Recommendation Report for Planning Permission

REF NO: LU/164/21/PL

LOCATION: Felix Dancewear
39 Beach Road
Littlehampton
BN17 5JA

PROPOSAL: Part change of Use from office/storage on first floor to 1-1 bed flat (resubmission following LU/100/21/PL). This site may affect the setting of a listed building & is in CIL Zone 4 (Zero Rated) as flats.

PROPOSED FIRST FLOOR

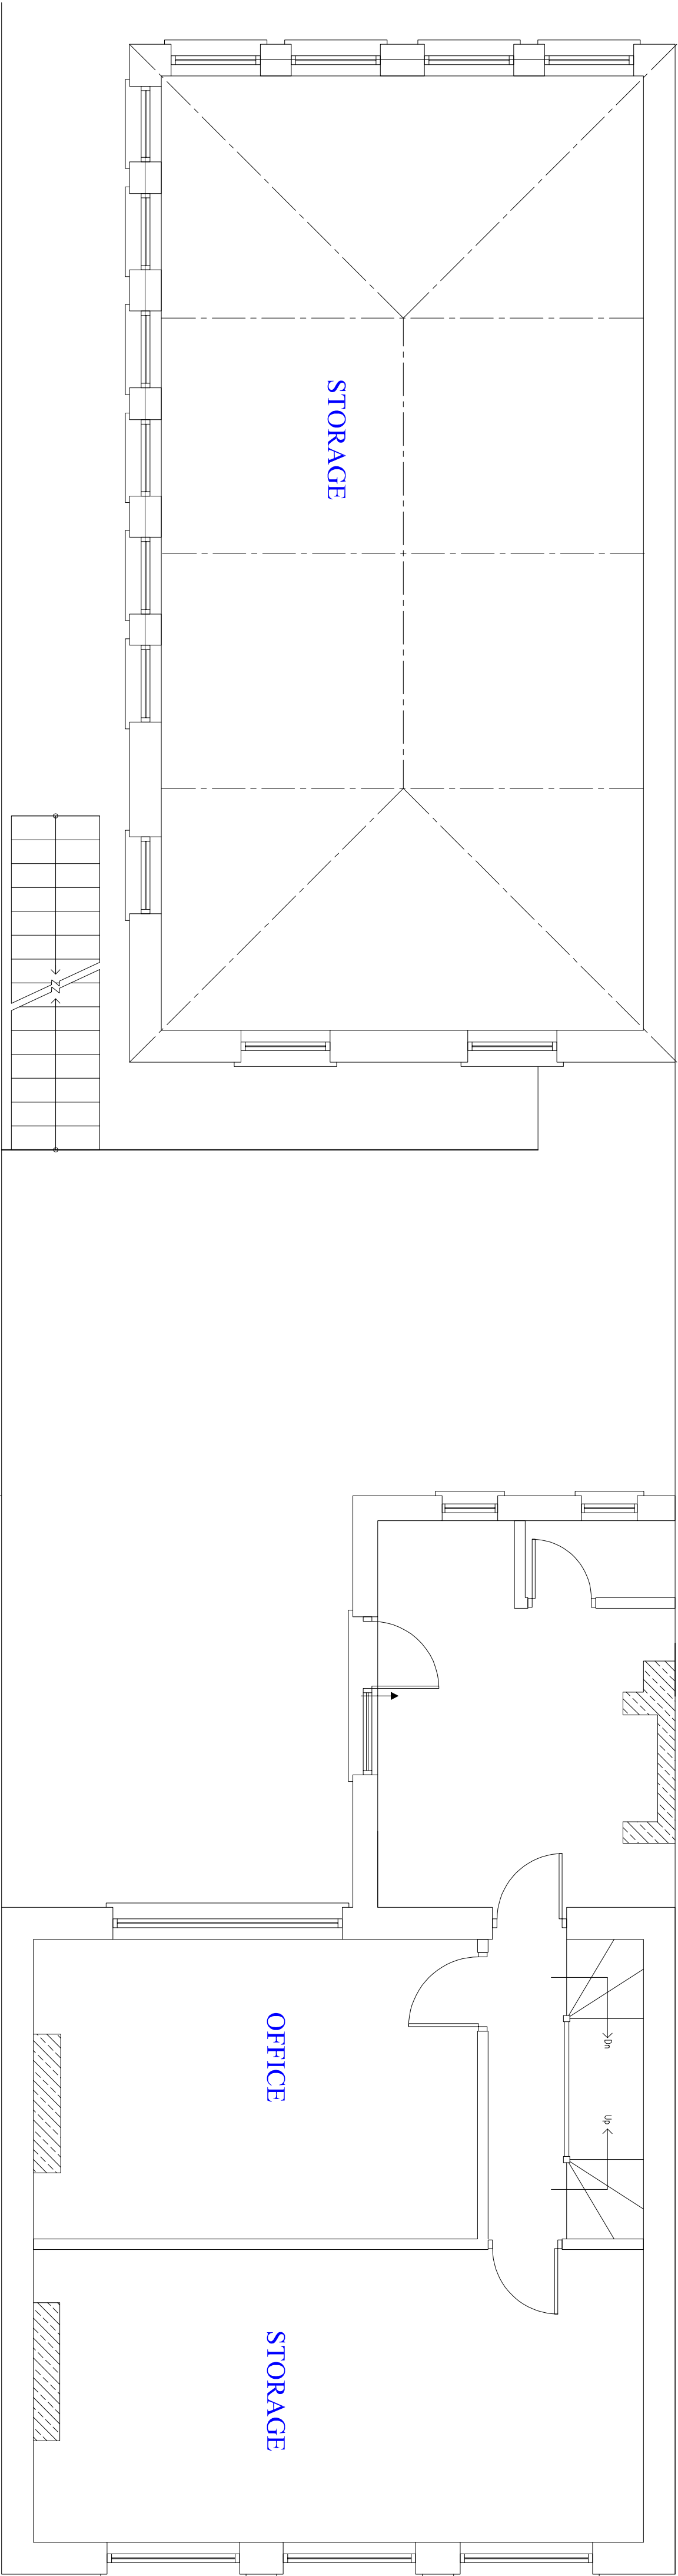
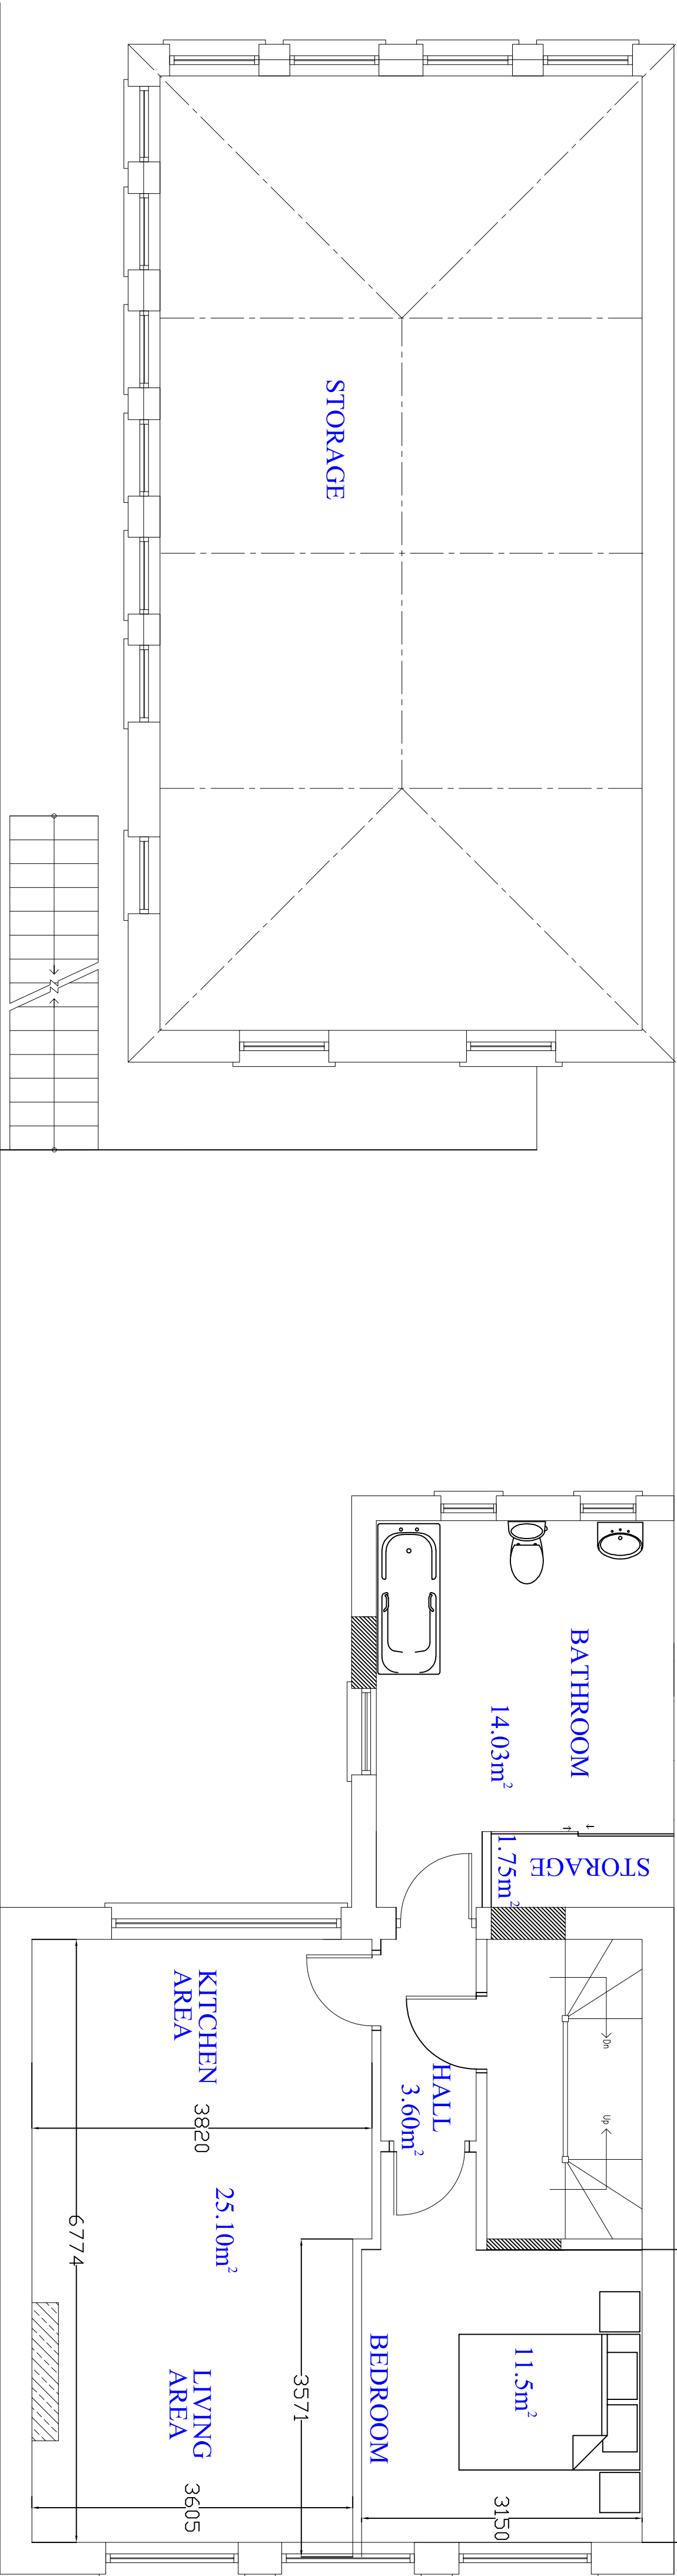
The 1bed/2persons flat would have an internal space area of 50.2sqm whilst the requirement according to the space standards is 50sqm. The proposed flat would satisfy minimal space standard required by the Nationally Described Space Standards.

PROPOSED SIDE ELEVATION

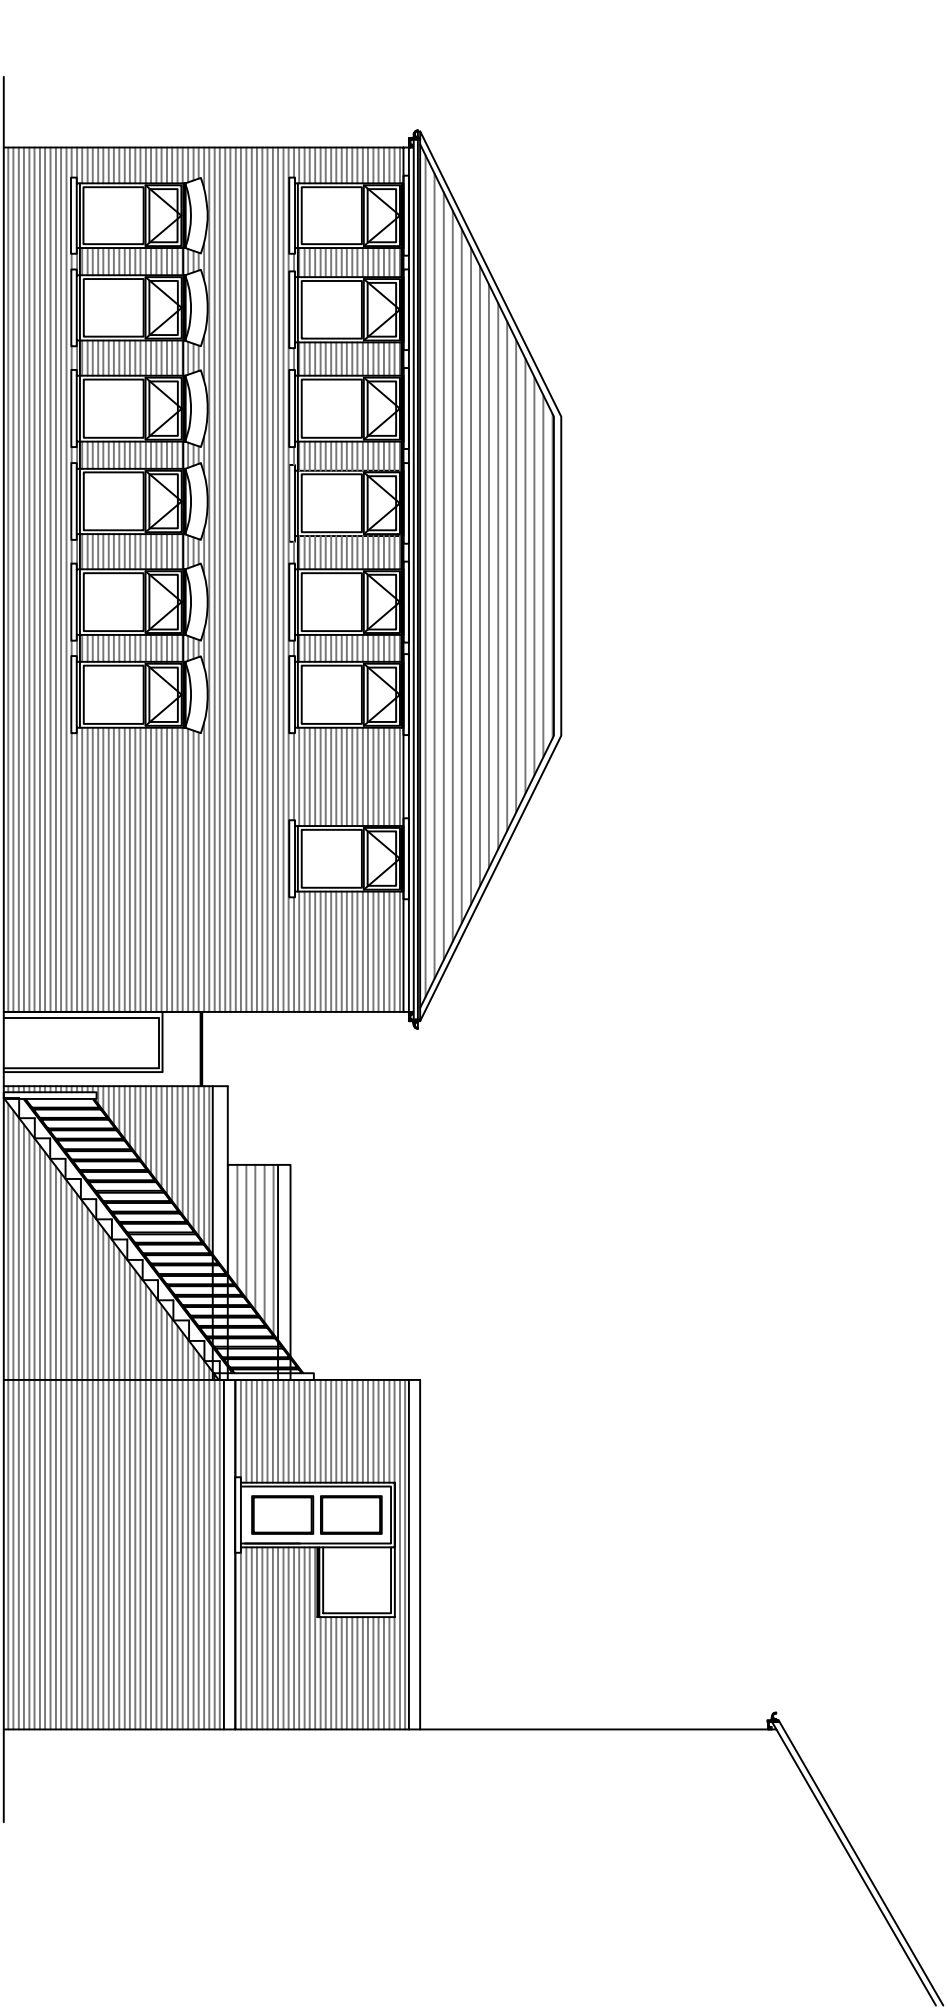
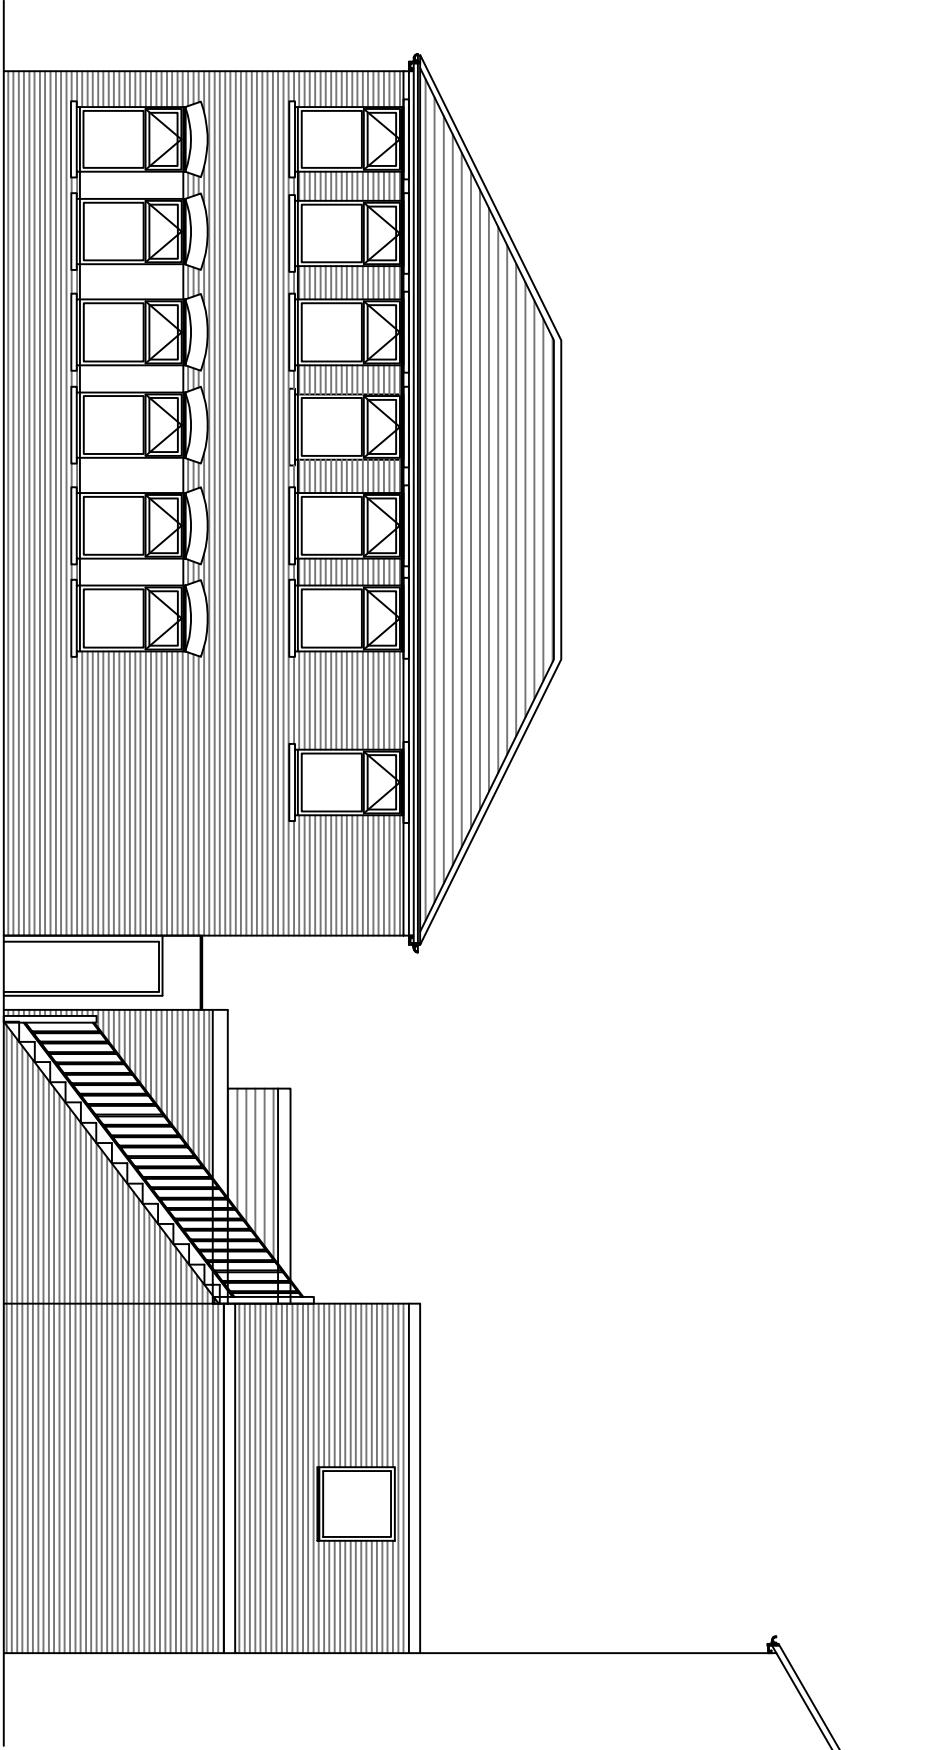
There are no changes proposed to the external appearance of front elevation. The proposal will transform existing upper floor into a 1bed flat. The rear elevation of the proposal property faces onto exist of car park, Tyrell Autos and church yard of The Church of St Mary. There are no changes proposed to the rear elevation; the existing door on the north western elevation would be bricked up.

Since the proposed change of use from office and storage resulting in 1 bed flat above the existing shop within mixed use area and would involve the internal changes only (except of north western elevation which will be invisible from the public area the proposal would not detract from the local and wider area's character.
